**Harnett County**  
420 McKinney Pkwy  
LILLINGTON, NC 27546  
Phone:  
Fax:

**SUBJECT: SFD2402-0046**  
**SINGLE FAMILY DWELLING**

Here are the results of all Inspections located at **691 KRAMER RD:**

site plan
Patrick J. and Alice A. O'Kelley
 plat book 2012 page 88-89
 Barbecue Township
 Harnett County N.C.
 Scale 1" = 100' Feb. 13, 2024

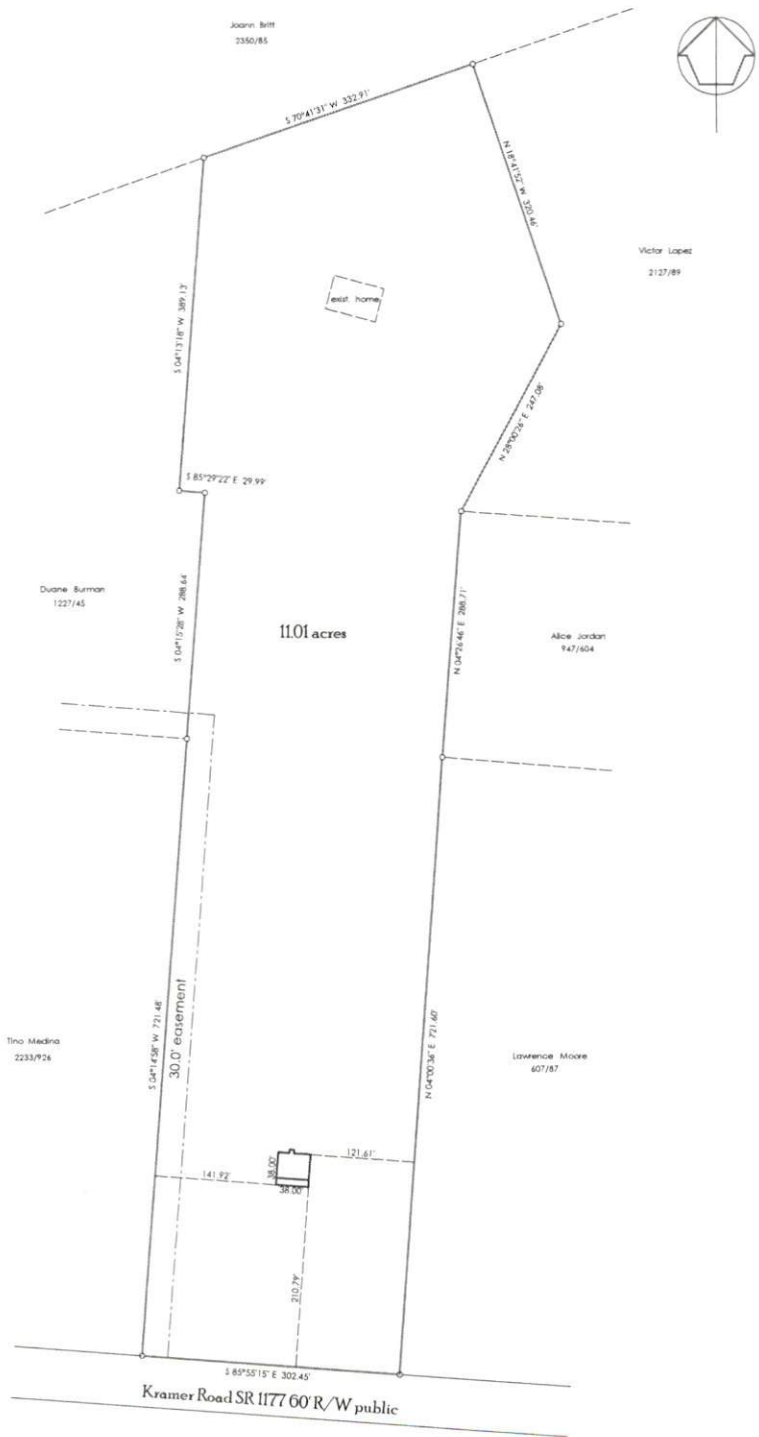
2nd home on lot  
Will this have it's own individual driveway or will it use the same driveway access off Kramer Rd as 709?  
SITE PLAN SHOWS 2ND DRIVEWAY. 691 KRAMER RD LILLINGTON 27546. POS ADDRESS SIGN AT ROAD.

Inspection Type: ADDRESS  
Scheduled Date/Time: 3/22/2024  
Completed Date/Time: 3/25/2024  
Inspector: GIS Bucket  
Result: APPROVED  
Remarks:  
Notes: SITE PLAN SHOWS 2ND DRIVEWAY. 691 KRAMER RD LILLINGTON 27546. POS ADDRESS SIGN AT ROAD.
